EAST PRESTON PARISH COUNCIL

19th December 2018

Re: EP/166/18/HH – 100 Sea Road, East Preston, BN16 1NP

Printed Date As Shown on A1
15/11/2018
Drawing Number 18075/02R2

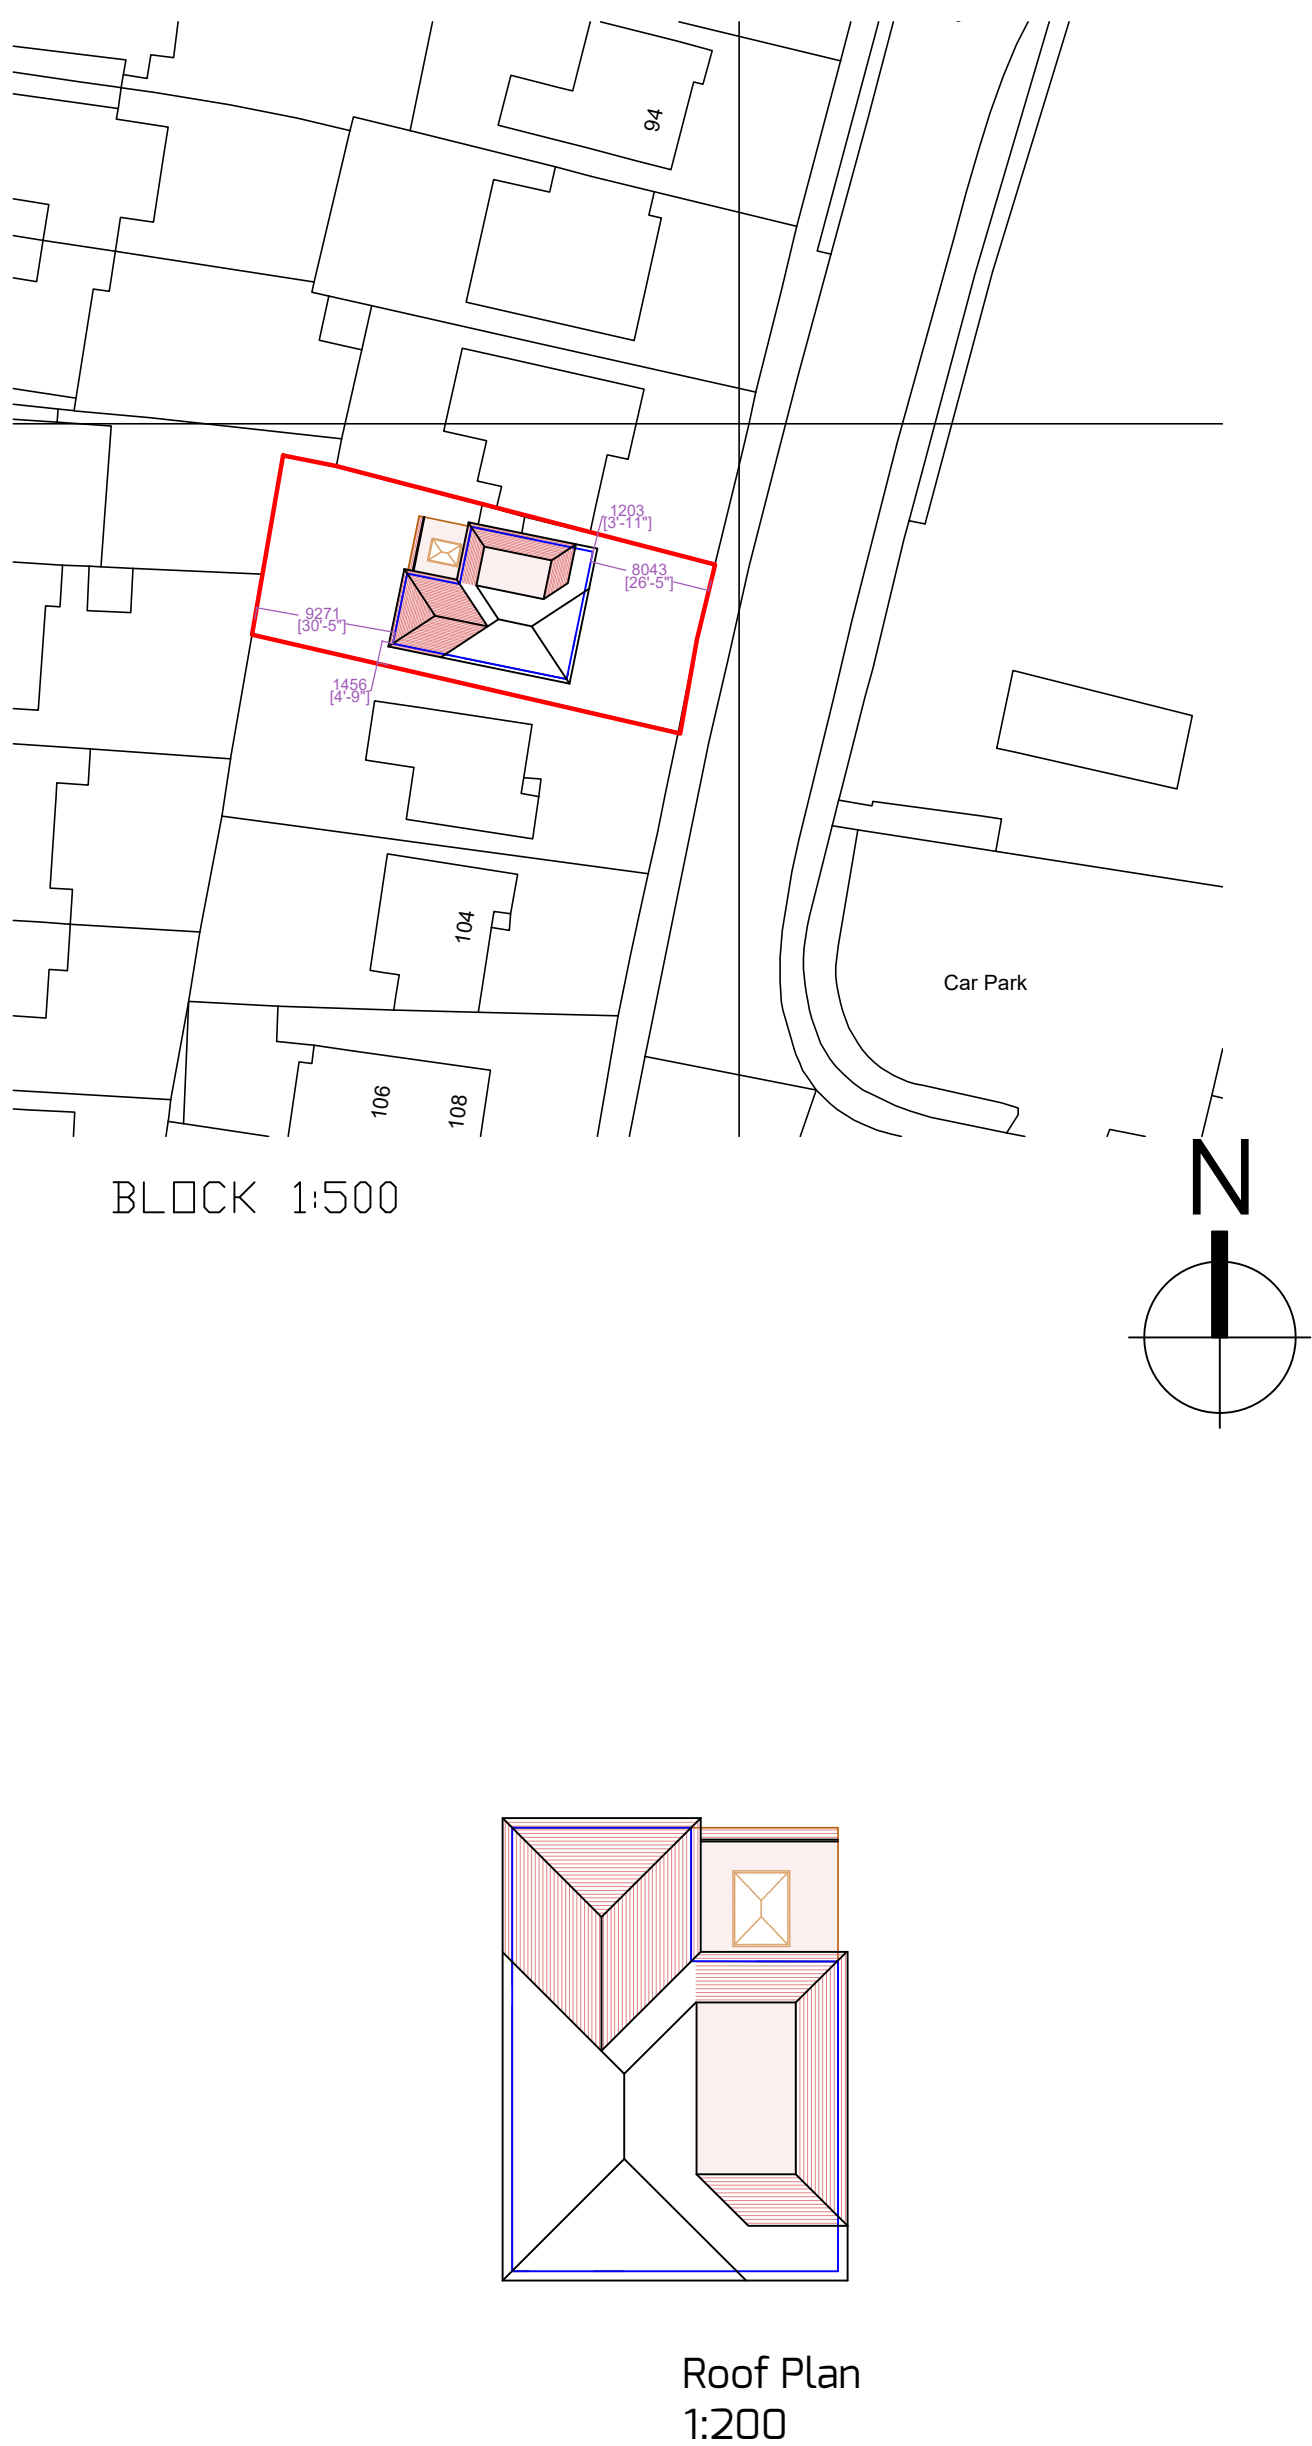
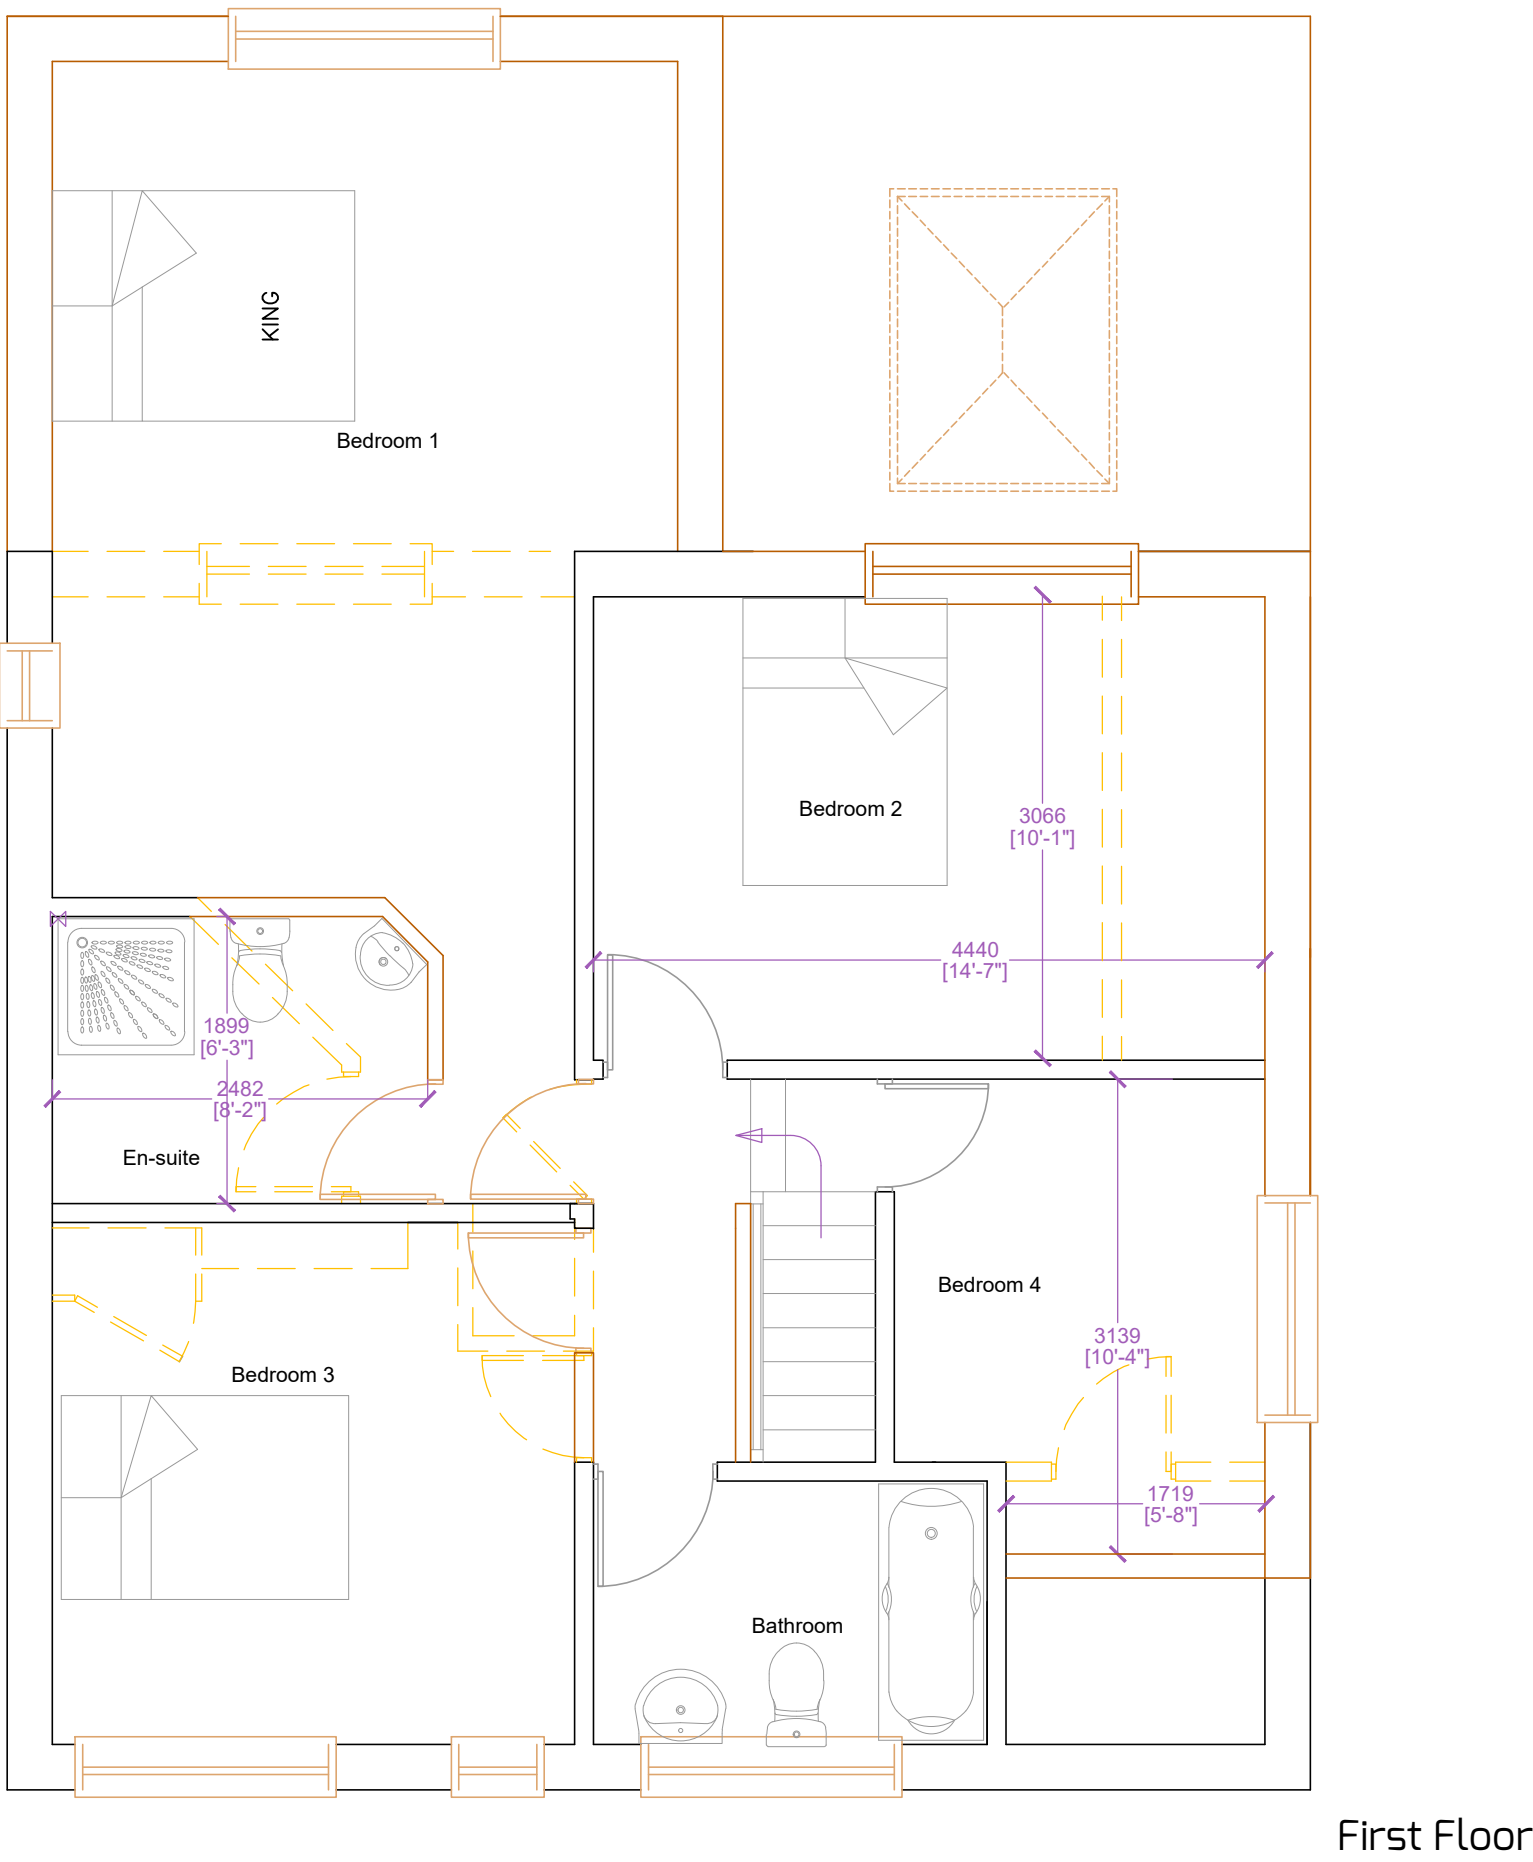
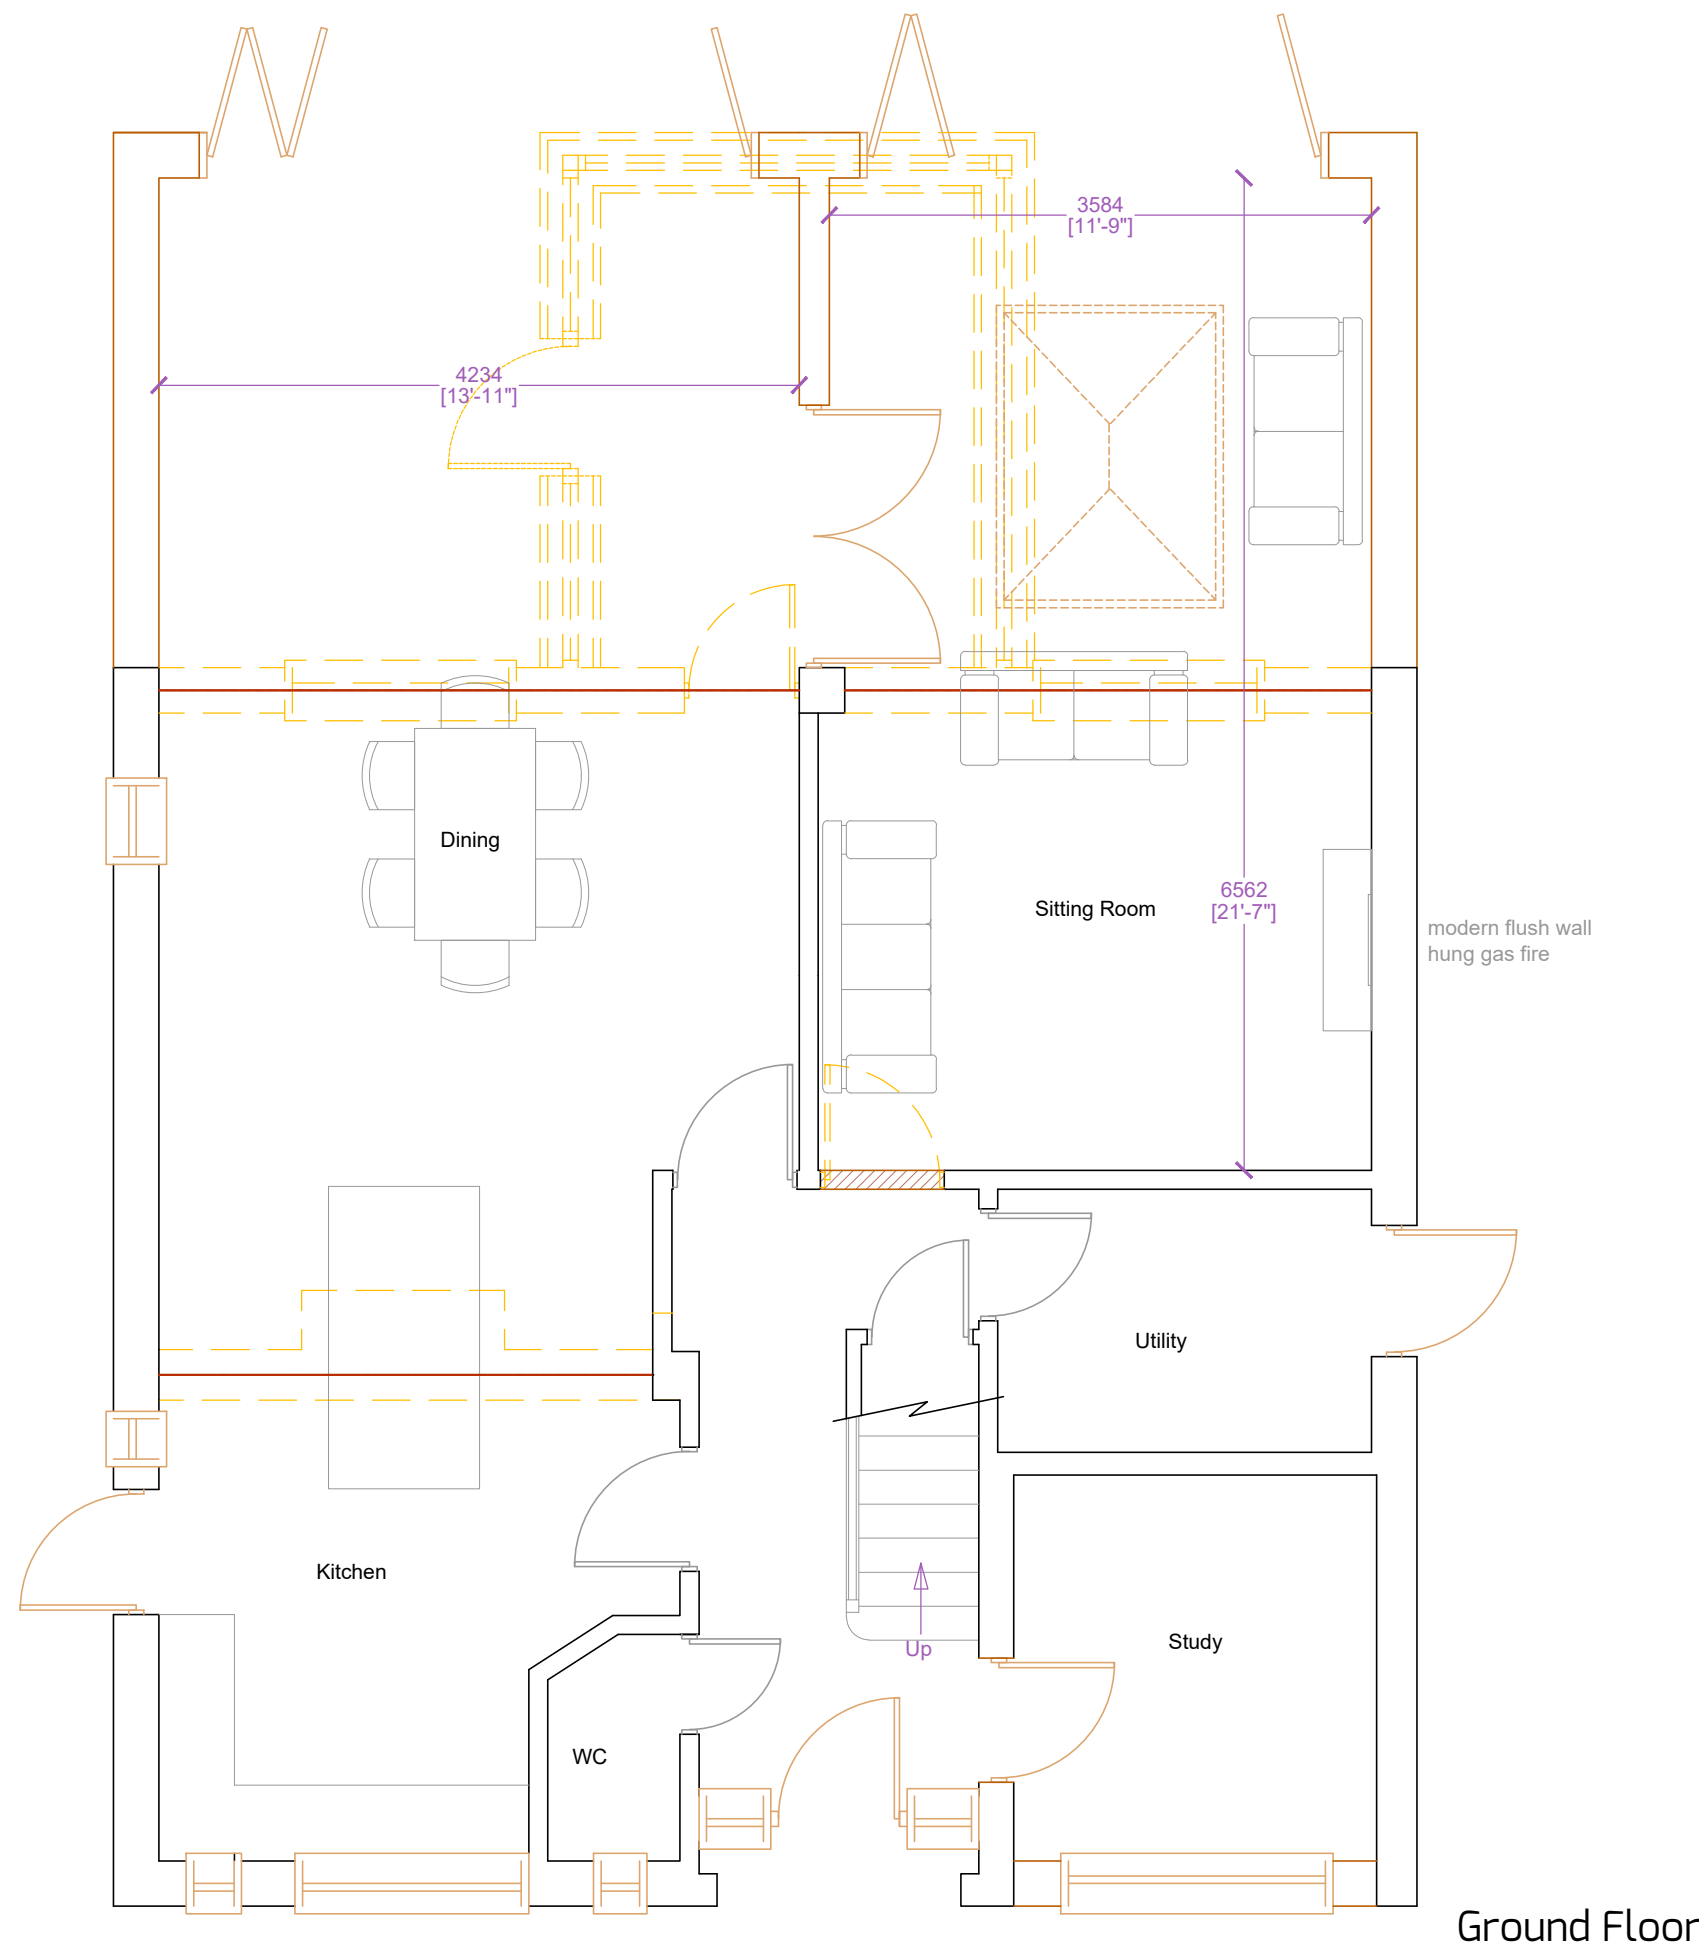
The proposed two-storey extension will be unneighbourly and overbearing both to properties in Sea Road but more importantly, to properties in Normandy Lane, to the west of the development site, as these are all bungalows. The two-storey extension will bring the two-storey part of the building much closer to the boundary with the properties in Normandy Lane, two of which share a boundary with 100 Sea Road. We believe the two-storey extension is contrary to Policy D DM1 of the Arun Local Plan, part 3, which states development should "[h]ave minimal impact to users and occupiers of nearby property and land. For example, by avoiding significant loss of sunlight, privacy and outlook". The proposal may also be contrary to Policy D DM4 of the Arun Local Plan which specifically concerns extensions to existing properties. Section c. of the policy states "the extension or alteration [should] not have an adverse overshadowing, overlooking or overbearing effect on neighbourhood properties" – as stated above, this council feels neighbouring properties in Normandy Lane and Sea Road will be adversely affected.

This Application proposes to lose the existing decorative leaded lighting of the front windows, the decorative, feature brickwork between the upper floor windows, the attractive brickwork above the ground floor windows, the wooden beam above the front door and to render over the exposed timbers on the front elevation. These are all attractive and distinctive features of the existing property and its neighbours. We believe the removal of these design features is contrary to Policy D DM1 of the Arun Local Plan as the proposal does not “make the best possible use of [...] building materials [...] and design features” and would result in a bland, featureless elevation, totally out of character with neighbouring properties. Removal of these features is also contrary to Policy 1 of the made East Preston Neighbourhood Plan as these alterations do not “reflect and enhance the architectural and historic character [...] of the surrounding building”. Policy 2 of the Neighbourhood Plan also states, “alterations to existing buildings, will: preserve the street scene”. Drawing 18075/02R2 states in the Elevations key, “5 – New rendered wall to match existing”, but there is no existing rendered wall on the front elevation to be matched with – side elevation yes, front elevation no.

Although not easy to read on the drawings, it is possible the two-storey extension is less than 1m from the boundary with no. 102; this would be contrary to Policy D DM4 of the Arun Local Plan, specifically Section d, “[...] any extension or alteration at first floor level does not come to within a minimum of one metre of the side boundary.”

The existing dormer on the northern elevation of the property will be lost but matches with the dormers on the two properties immediately to the north of this property. This will have an unacceptable impact on the host property and unacceptable negative impact upon the uniform character and appearance of neighbouring properties in conflict with Policies D DM1 and D DM4 of the Arun Local Plan and the National Planning Policy Framework.
